Our ref: OR-0001625/01
Your ref: EN010153
Date: 28 April 2026

ENVIRONMENT AGENCY'S DEADLINE 2 RESPONSE

EAST PARK ENERGY

Figure 9 - 1.0% AEP +40% CC Maximum Modelled Flood Depth - AB Model Area

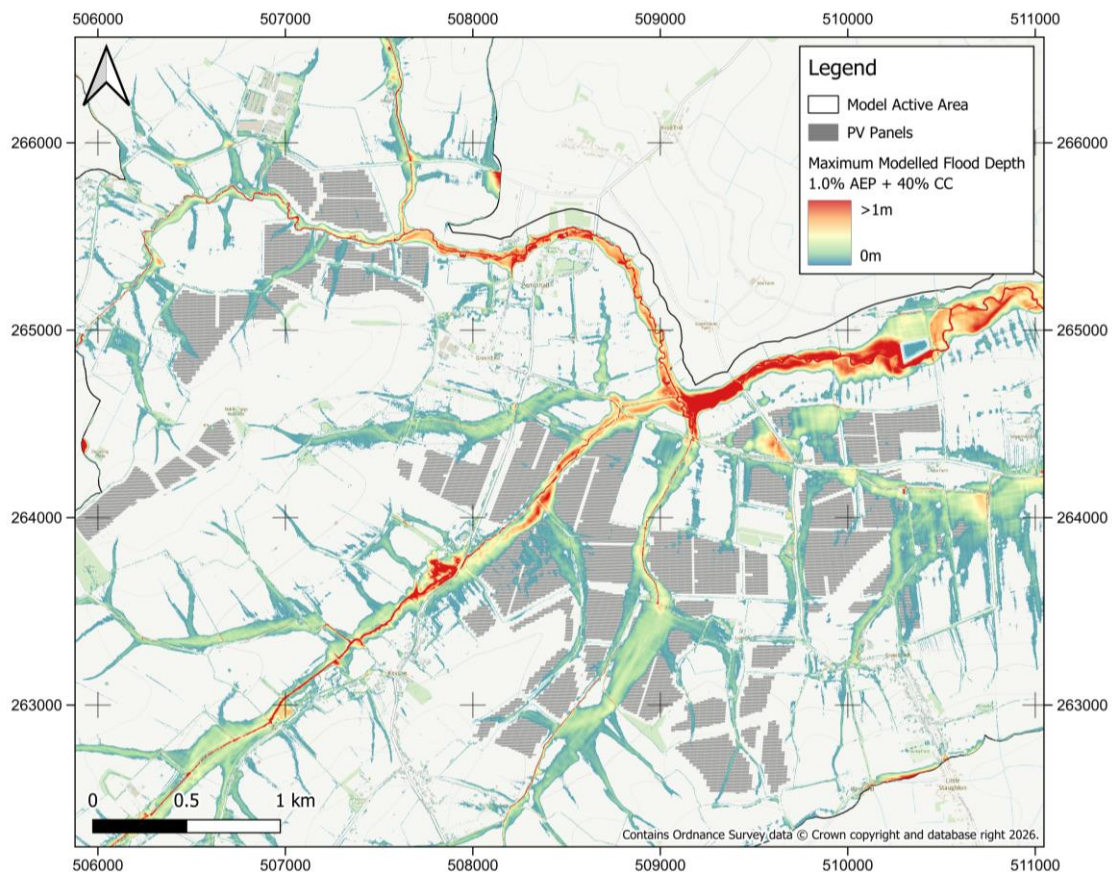
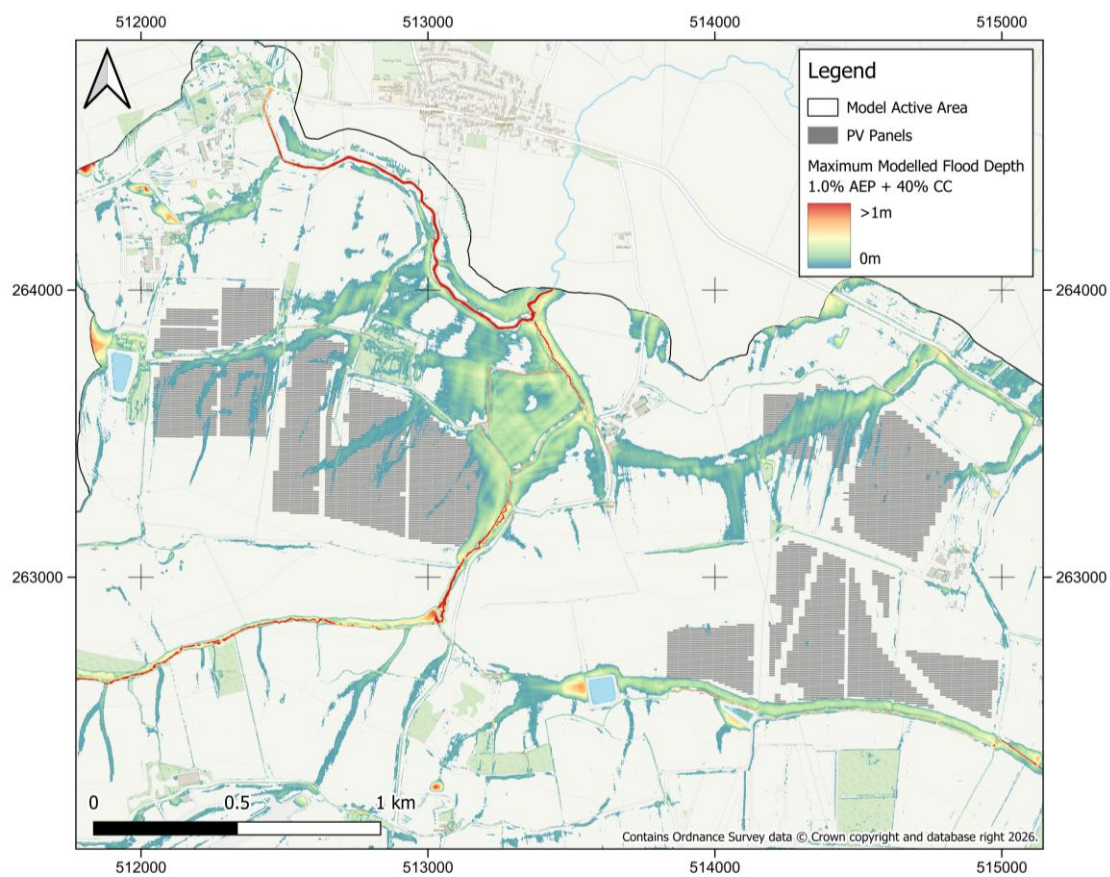
We required the Applicant to review the freeboard allowances for solar panels and provide evidence that the Risk of Flooding from Surface water mapping is a representative or conservative proxy for the fluvial design flood event and credible maximum scenarios.

However, to resolve this issue the Applicant should include details within the Appendix 8-1: Flood Risk Assessment of Chapter 8 Hydrology and Flood Risk [REP1-010] regarding the volume of storage lost from solar panel support frames and the effect on flood risk elsewhere. This will demonstrate the development is compliant with policy, in particular paragraph 5.8.12 within the Overarching National Policy Statement for Energy (EN-1).

The Applicant updated Chapter 8 Hydrology and Flood Risk [[REP1-010](#)]. The outputs of the modelled flood have led to the appropriate mitigation measures (which include allowances for climate change) outlined below, these are considered acceptable:

- The extent of flooding affecting proposed solar panels is minor and mostly mitigated by the 800mm panel raise providing at least 300mm freeboard above maximum water level. Small areas show greater depths of flooding and additional raising is proposed to mitigate this and maintain 300mm freeboard.
